WELWYN HATFIELD COUNCIL – DEVELOPMENT CONTROL
DELEGATED REPORT

APPLICATION No:	S6/2007/1417/FP
------------------------	------------------------

DESCRIPTION OF PROPOSAL:

Rev:			
Scale:	Date:	Drawn :	Checked :
1:100	Sept 07	BS/PKS	
Dwg. No.:	1239 - 03c		Rev.

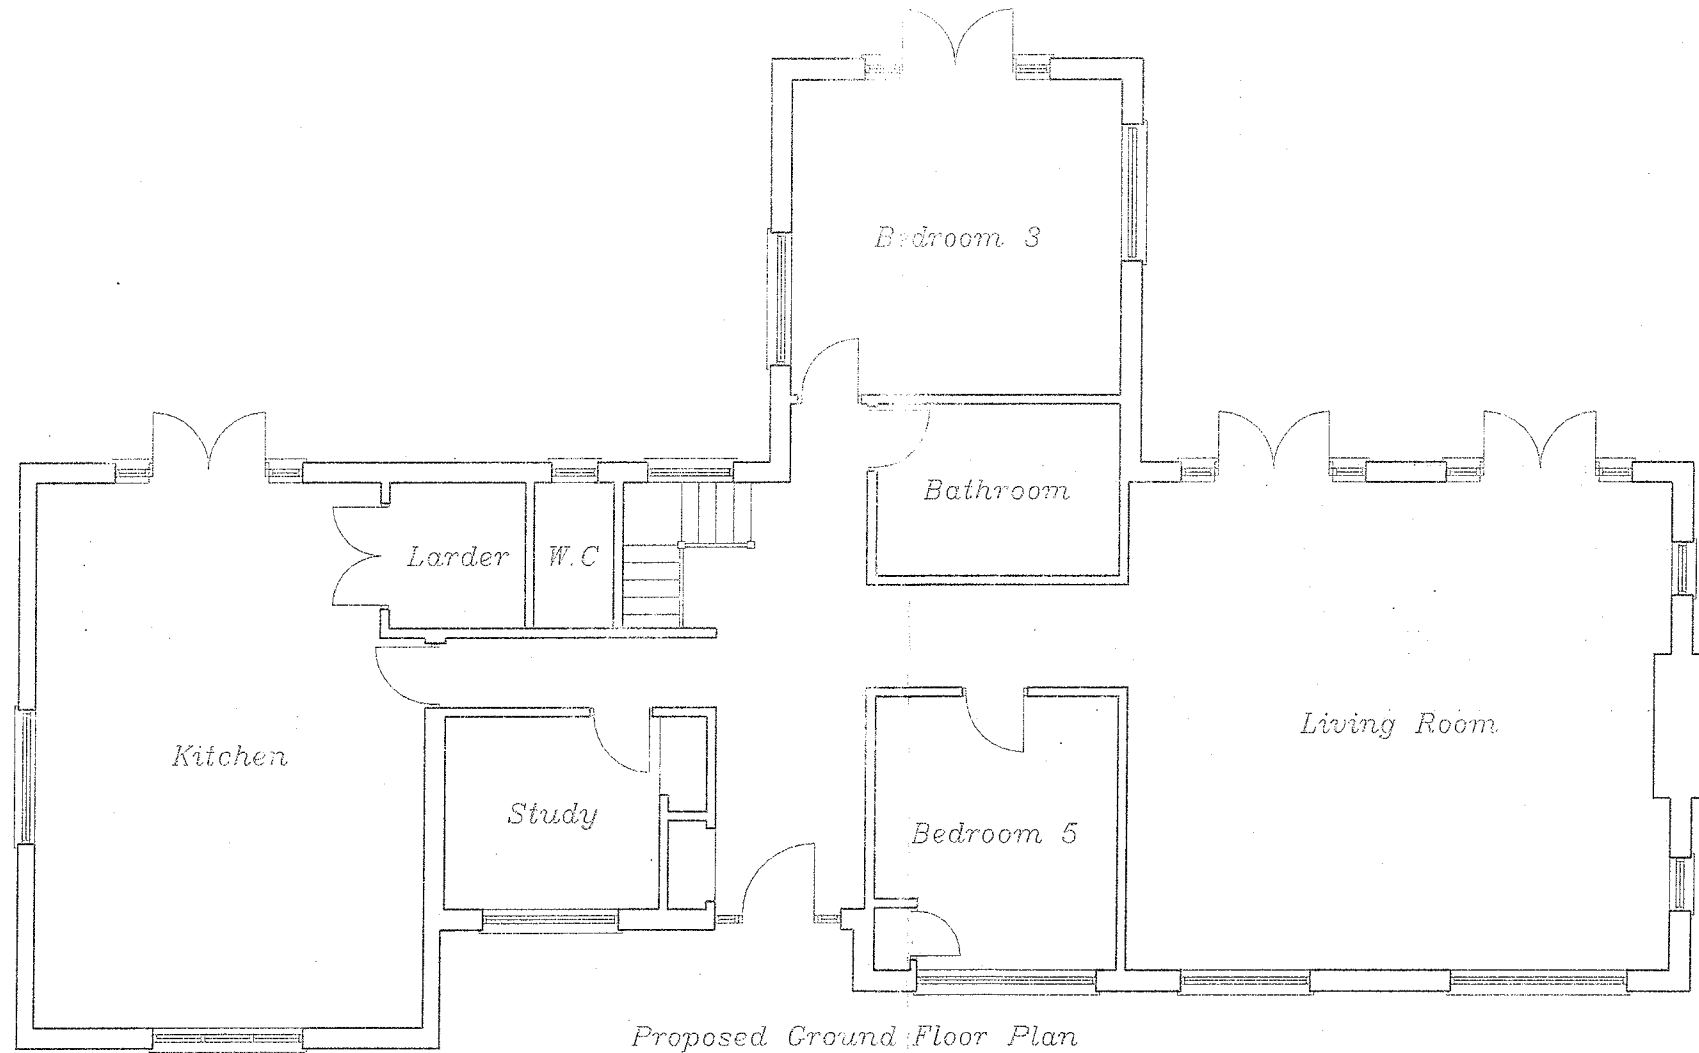
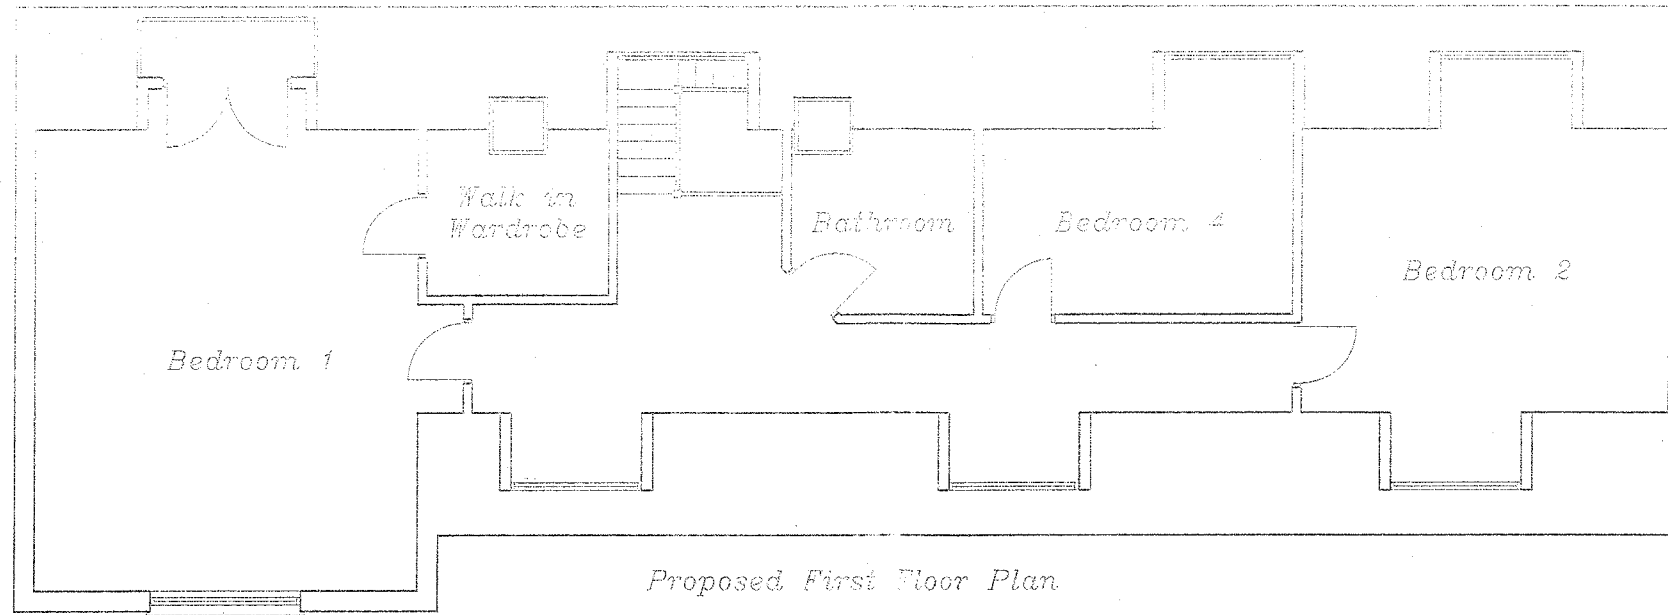
The existing access to Bell Lane is to remain unchanged, and although the existing garage is to be converted into habitable accommodation, there are at least 3 parking spaces to the front of the dwelling which is sufficient for the proposed 4 bedrooms. The proposal therefore complies with Policy M14 of the Welwyn Hatfield Plan 2005 and the accompanying Supplementary Design Guidance – Parking Standards.

Rev:	Date:	Drawn:	Checked:
Scale: 1:100	Sept 07	BS/PKS	
Dwg. No.:	1239 - 04d		Rev.

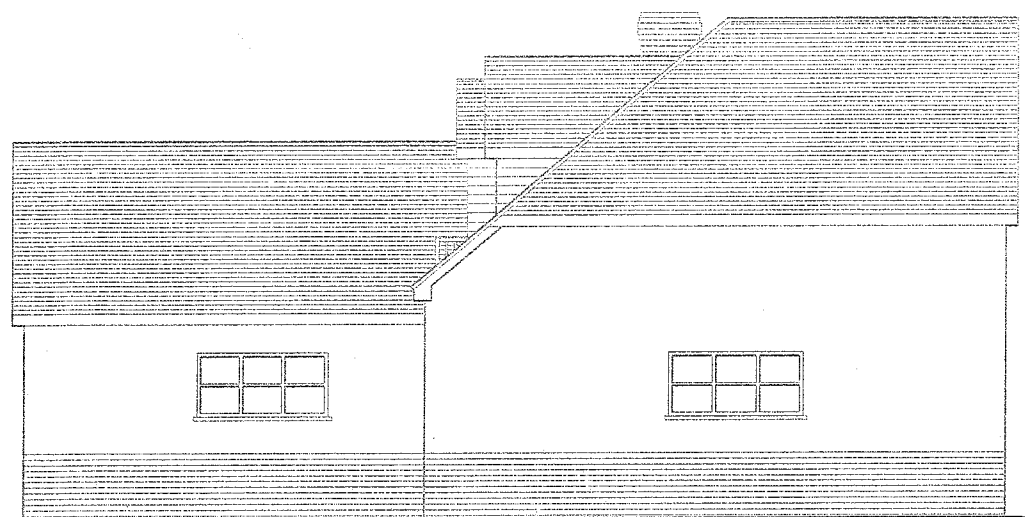
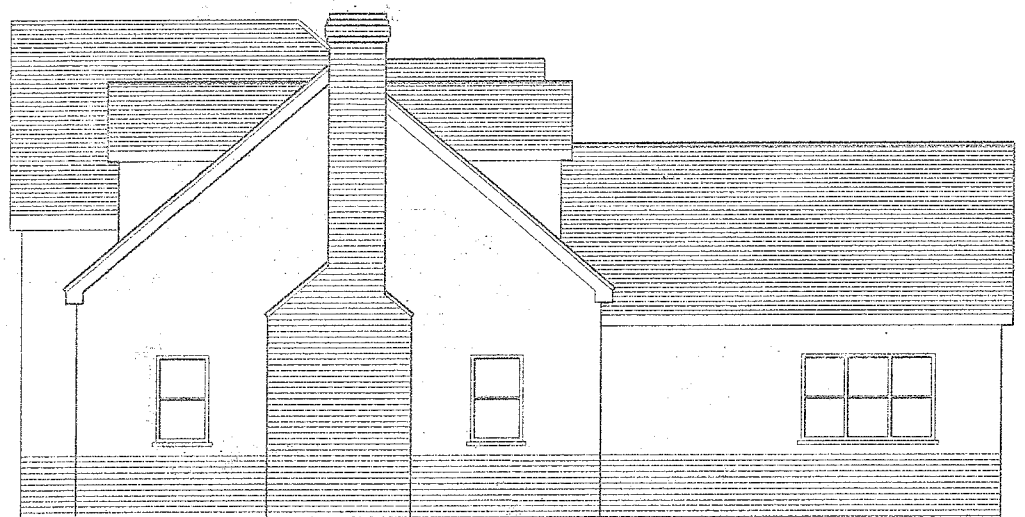
The dormers and the changes to the window and door fenestration to the rear and side are relevant as the other changes to the existing building were covered in the previous application.

The size of the proposed dormers are still subservient to the appearance of the new roof slope and so would comply with the guidance of the Supplementary Design Guidance and would be in keeping with the character of the overall design. The changes to the windows and door arrangement is also considered to be acceptable.

Due to the isolated location of the application property, it is considered that the proposal will have no undue impact on the amenity of adjoining neighbours in terms of privacy or that it would appear overly dominant. The enlarged dormers would not
